**App no: 24.0439**

**Address: Duke of York Inn Grindleton Brow Grindleton**

**Proposal: Application for planning permission for change of use from public house with living accommodation to residential use. Demolition of side and rear extensions and construction of single-storey extension to side and detached garage. Alteration to vehicle access and creation of domestic curtilage**

5977 - P33 REV A

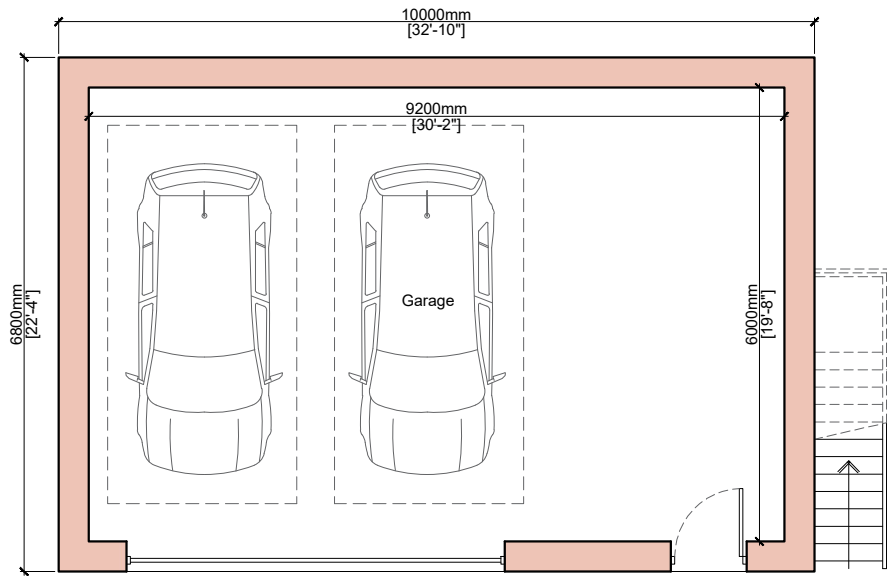
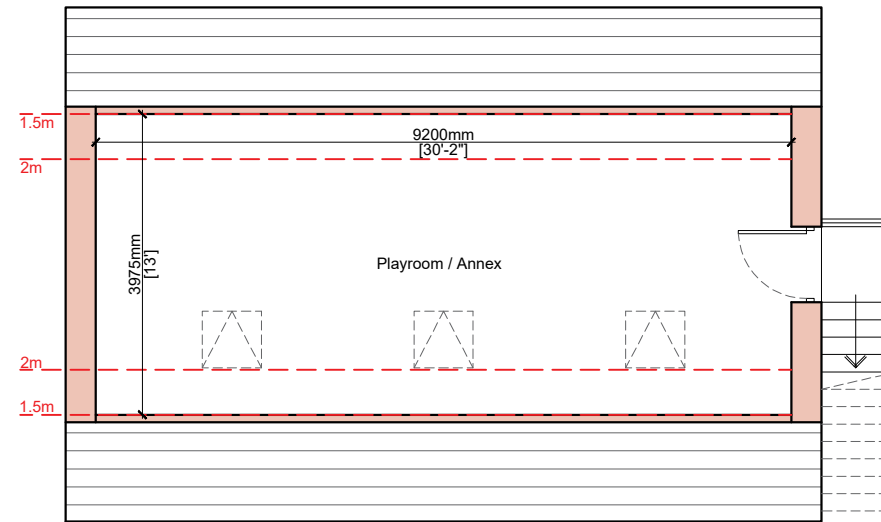
There is driveway space for 3+ vehicles and the proposed detached garage measures 6m by 9.2m internally and is designed for 2 vehicles and will provide sufficient cycle storage.

We would request that the garage is used only ancillary to the dwelling.
